An
Coimisiún
Pleanála

Inspector's Report ACP-323891-25

Development	Uisce Éireann Compulsory Purchase (Adare Rationalisation) Order, 2025
Location	Castleroberts, Adare, Co. Limerick.
Planning Authority	Limerick City and County Council
Planning Authority Reg. Ref.	
Applicant(s)	Úisce Éireann
Type of Application	Compulsory Purchase Order.
Objectors	Edward Houlihan
Date of Site Inspection	13 th February 2026
Inspector	Bernadette Quinn

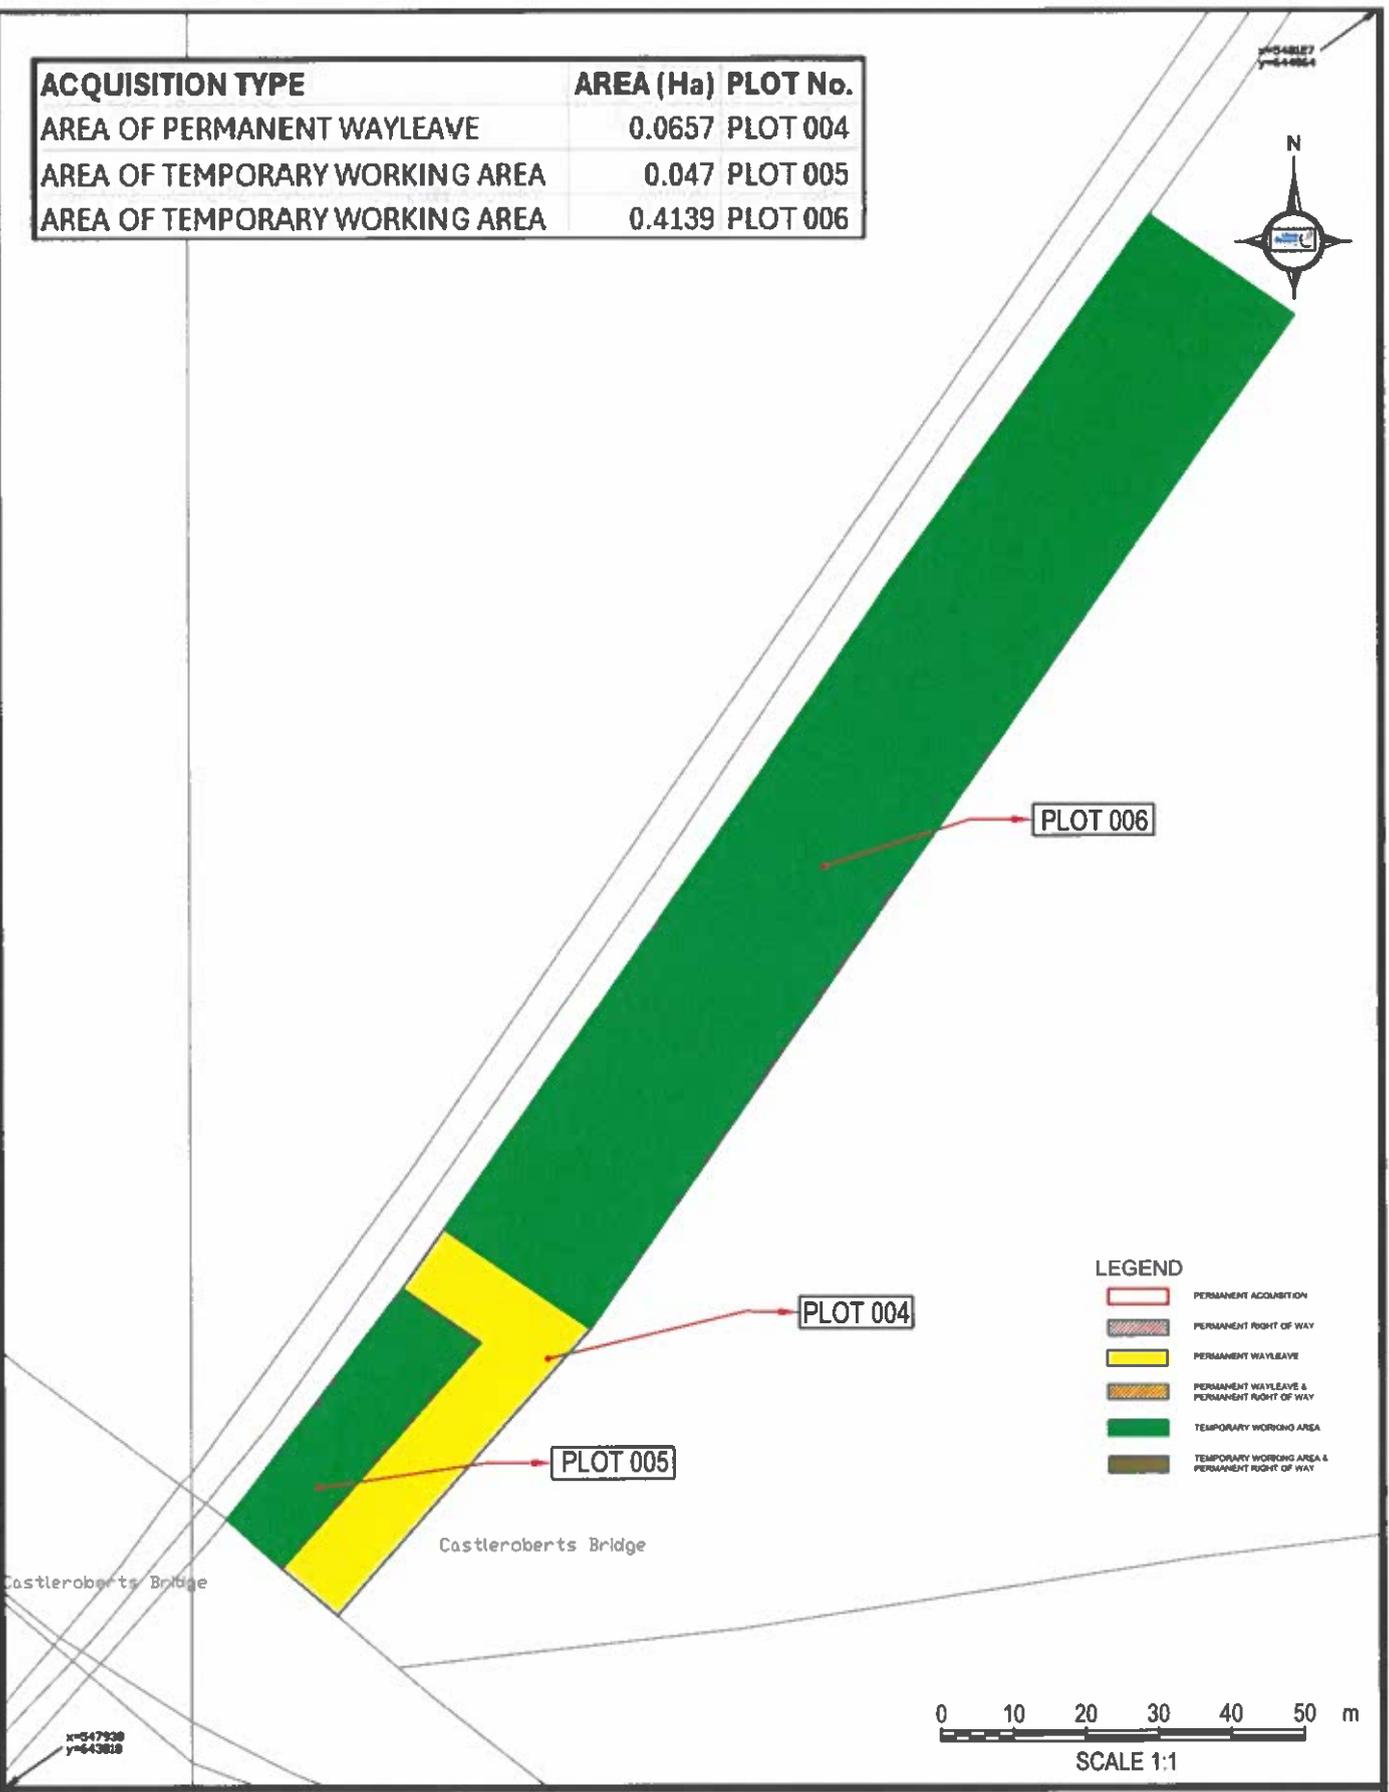
6.1. The Commission received a single objection in relation to the CPO. The objection is made by the landowner, Mr. Edward Houlihan (the objector) (represented by FBA Consultants), and relates to plot reference 004 (permanent wayleave with a stated area of 0.0657ha) and temporary working areas indicated as plot reference 005 (with a stated area of 0.047ha) and 006 (with a stated area of 0.047ha), as shown on drawing sheet no. UE/10051295/CPO/0001. The objection raises the following concerns:

- The objector is opposed to the proposed route of the scheme and requests that it be relocated to the opposite side of the public road from his landholding. This alignment will place the entire scheme on the same side as the existing treatment plant.

- The proposed route requires two road crossings and has at least three right angle joints which compromise pressure and are more prone to leaks.
- The proposed route has a greater cumulative impact on the three affected adjacent holdings at this location. The requested route therefore represents the more logical and appropriate route.

8.3.1. I highlight for the attention of the Commission that UE is not seeking to permanently acquire any lands from the objector. It is, however, seeking to acquire a permanent wayleave, being Plot No. 004, and temporary working areas, being Plots 005 and 006, along the proposed pipeline route.

8.3.2. I note that Plot Nos. Nos. 004, 005 and 006 are required to construct a pipeline under the Mague River so as to connect to a recently installed 450mm Ductile Iron connection point in Croom with an existing connection at Adare Reservoir where a 350mm Ductile Iron pipe terminates.
